From: leona sampson [REDACTED]
Sent: 16 November 2021 14:16
To: Harry Chalk <Harry.Chalk@arun.gov.uk>
Subject: Re: AW/316/21/T, Stratton 9 Kingsway, planning application amendments request.

Just wanted to request some amendments to the planning application of reference (AW/316/21/T) for address (Stratton 9 Kingsway).

REF 1

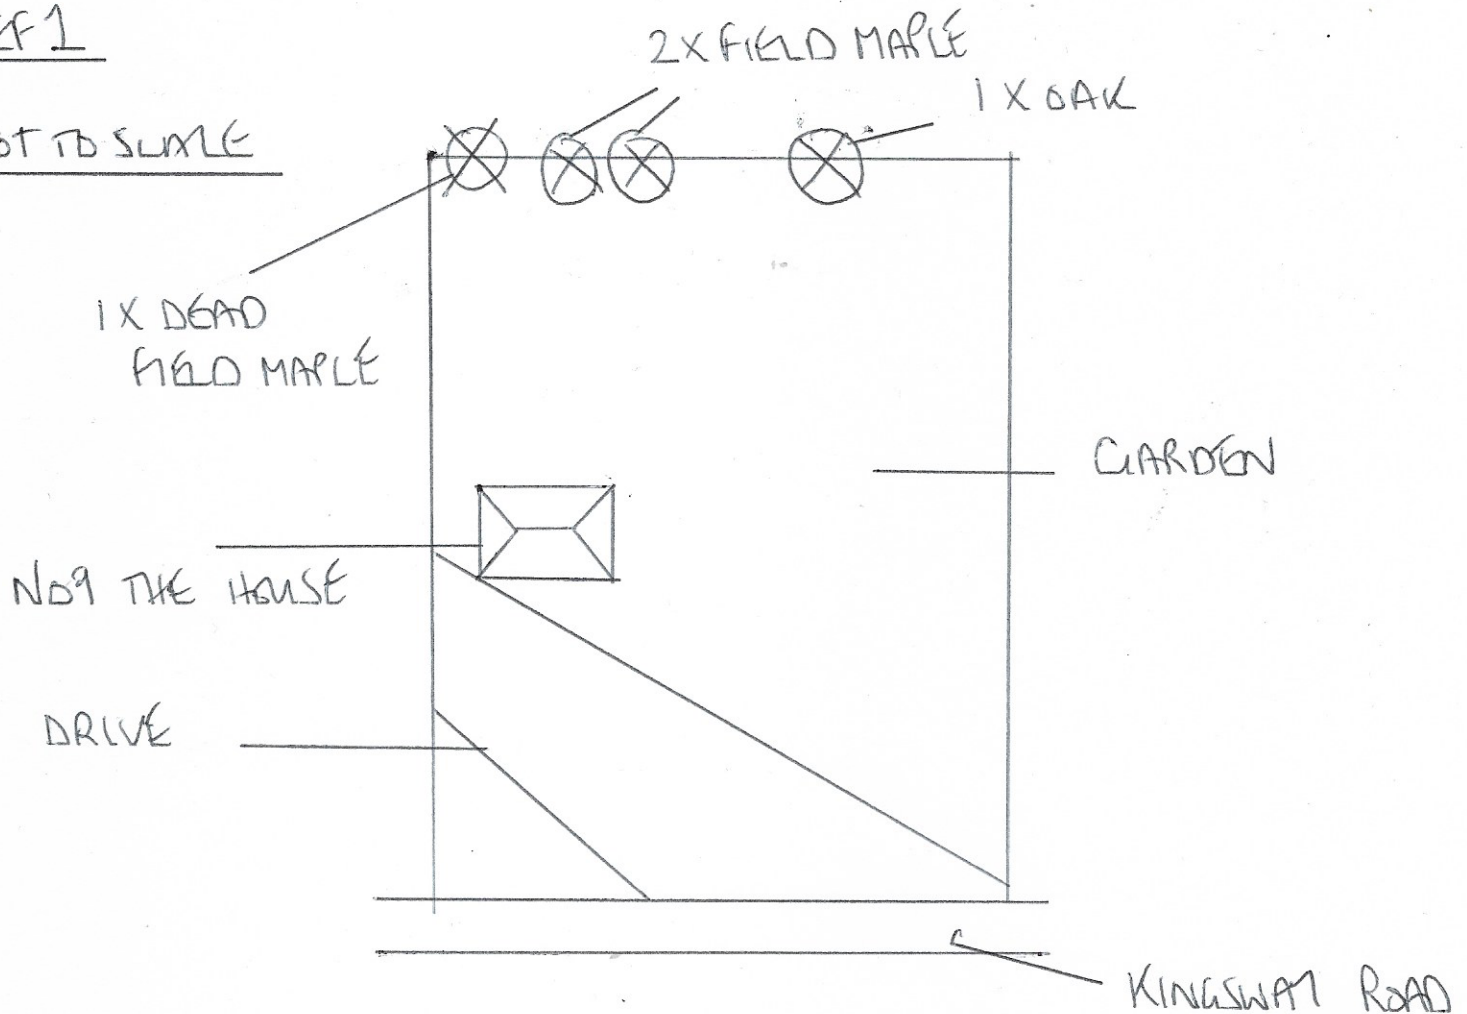
- The work proposed to T1 and T2 (maple) is justified on arboricultural grounds. There is limited scope for replacement planting as any tree of potential amenity value would struggle to establish beneath canopy of remaining trees. As such, we need not pursue replacement trees at this location but can take this opportunity to remind the applicant of the ecological value in standing deadwood and stump retention, wherever safe and practical to do so.

- T3 (oak) - The applicant has indicated concern about the stability of this tree but has not provided any physical evidence in support. My own ground-level visual assessment of the tree did not reveal any obvious signs of pathogen activity, structural defect or root-plate displacement; to suggest the tree could be structurally unsound and/or present an unacceptable level of risk for its location.

- For a tree of this age, stature, and apparent good health; a proposal to fell for the reason stated must be supported with evidence (e.g., ground disturbance, pronounced lean through to upper crown, video footage clearly showing atypical movement) to demonstrate the tree is most probably hazardous. If that evidence can be provided in support of a new application, it may be appropriate to propose crown reduction pruning instead of wholesale removal.

- I would like the applicant to be invited to agree to revise their work proposal (by removing T3 oak) as part of the current application so as not to incur further delay. Such work would go some way to addressing their concerns whilst preventing undue loss to the landscape.
- For a tree of this age, stature, and apparent good health; a proposal to fell for the reason stated must be supported with evidence (e.g., ground disturbance, pronounced lean through to upper crown, video footage clearly showing atypical movement) to demonstrate the tree is most probably hazardous. If that evidence can be provided in support of a new application, it may be appropriate to propose crown reduction pruning instead of wholesale removal.

Can I get written confirmation that you are happy for me to make the prior discussed amendments to your application and continue with it's due process. The amendments to this application would be as follows:
Description - Fell and remove 2 No. Field Maple trees.
